Subject: Pottinger Wind Farm – Response to Further Requests for Additional Information – TfNSW and BCS

We refer to the Department of Planning, Housing and Infrastructure's (DPHI) request for additional information regarding the Pottinger Wind Farm (SSD-59235464), in response to further RFIs from:

Pottinger Wind Farm

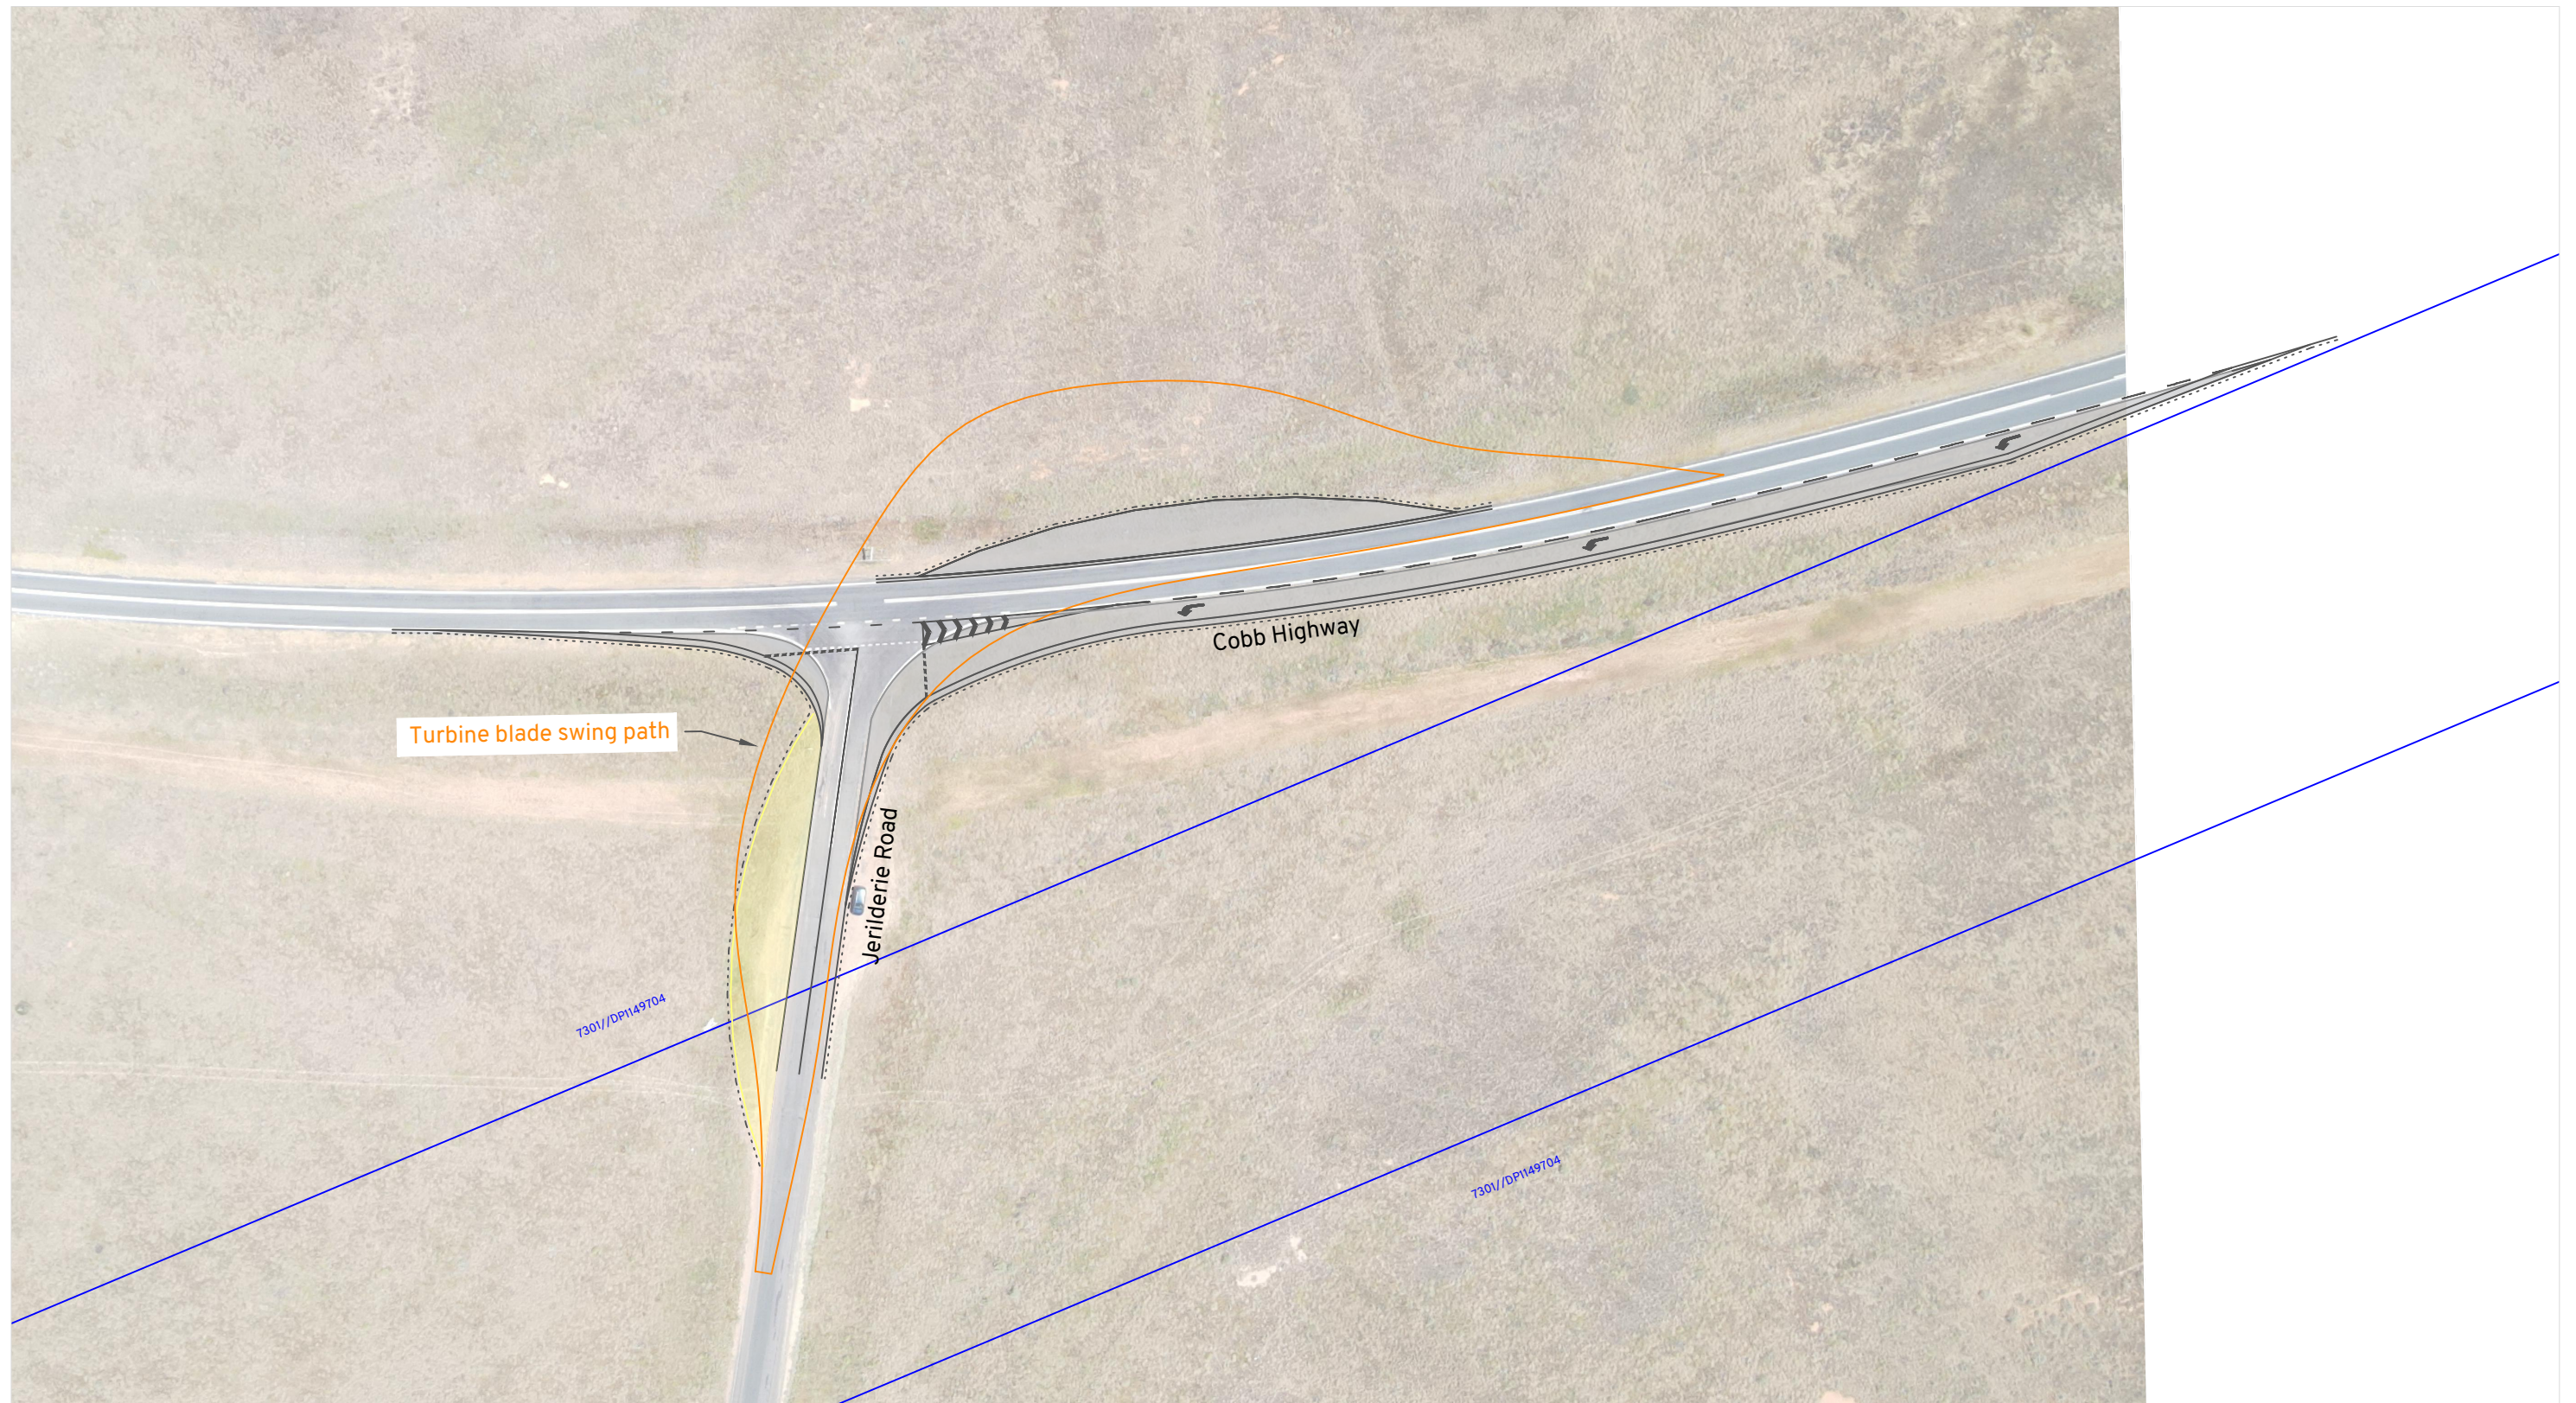
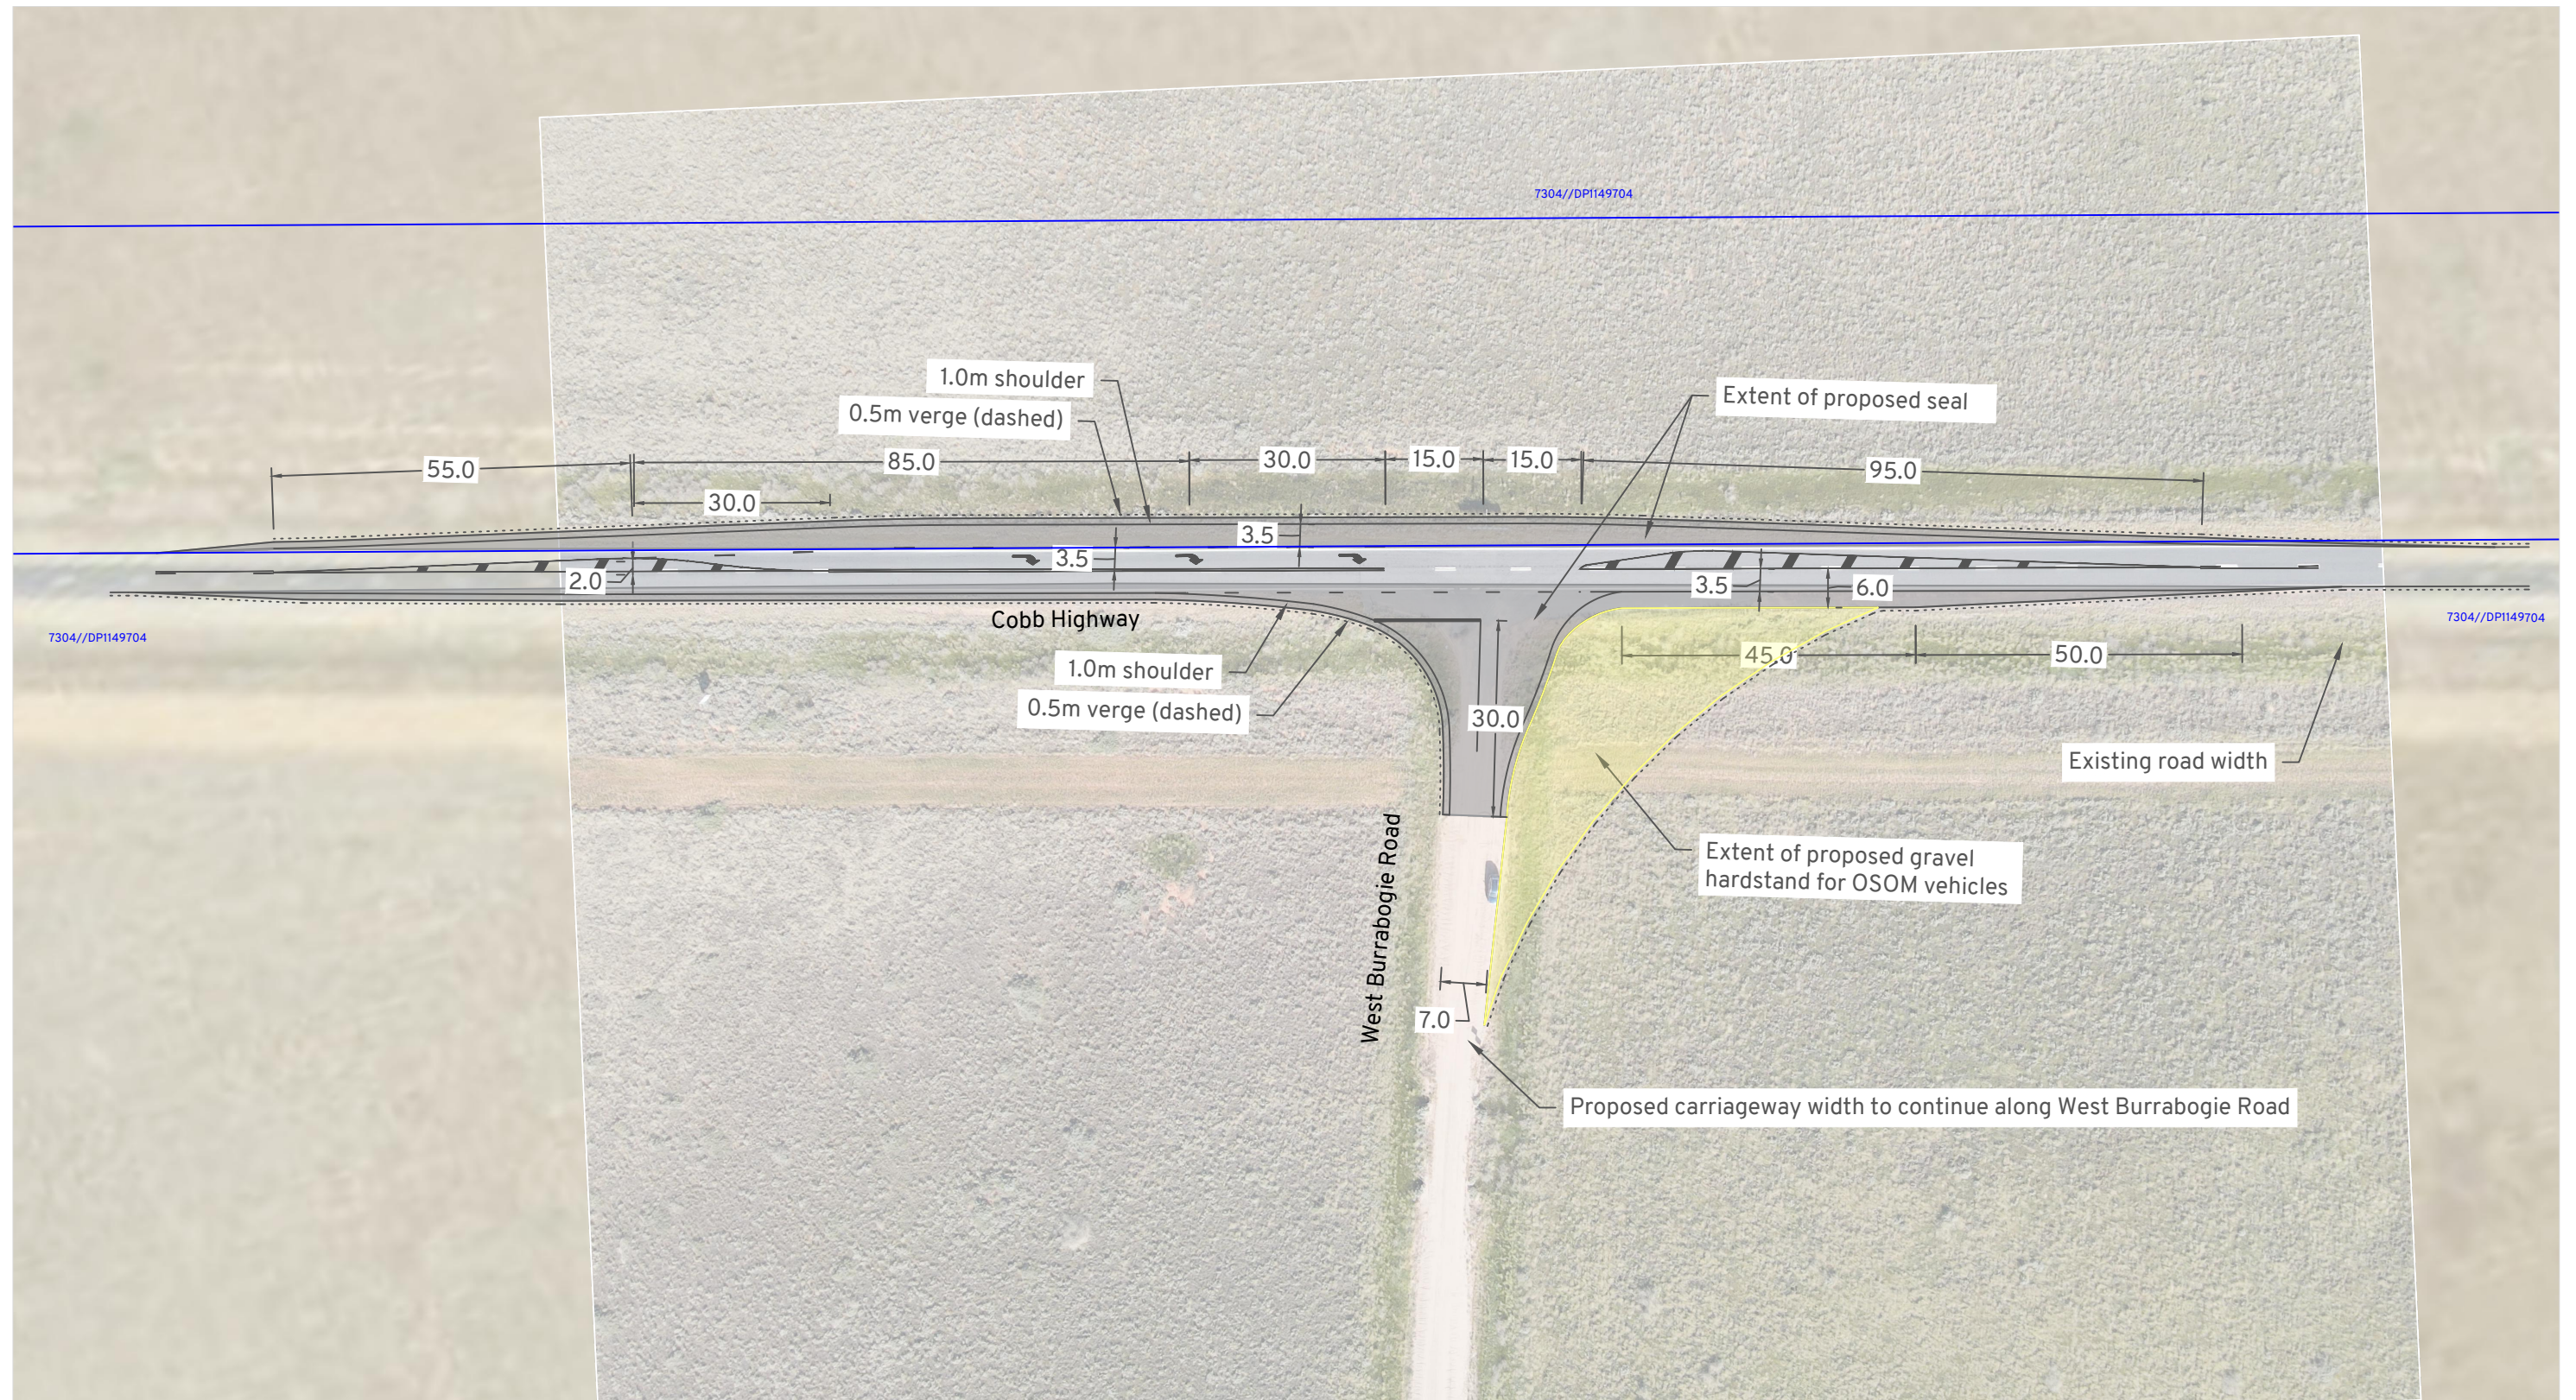
| Date | TfNSW request | Date | Response | Date | TfNSW Further Request | Date | Response |
|------------|---|------------|--|------------|---|------------|--|
| 16/01/2025 | Propose a method for the management of opposing traffic on the Cobb Highway and Barrier Highway (on sections where they have 3m wide travel lanes and no road shoulder), including during wet weather. If this method involves using pullover areas, the location and treatments of those pullover areas should be described. | 21/01/2025 | <p>Provided an indicative Traffic Management Method for Narrow Sections of Cobb and Barrier Highways, written by Amber (traffic expert).</p> <p><u>Please see Appendix E for final document.</u></p> | 24/01/2025 | Further requested a strategic design of a pull over bay including treatment type and design to be assessed / overlayed against the locations identified in the methodology to understand how it fits within the road corridor. | 30/01/2025 | <p>Provided a list of Cobb Hwy Temporary Pullover Bay Options</p> <p><u>Please see Appendix F</u></p> <p>Provided strategic design of a pullover bay.</p> <p><u>Please see Appendix G</u></p> |
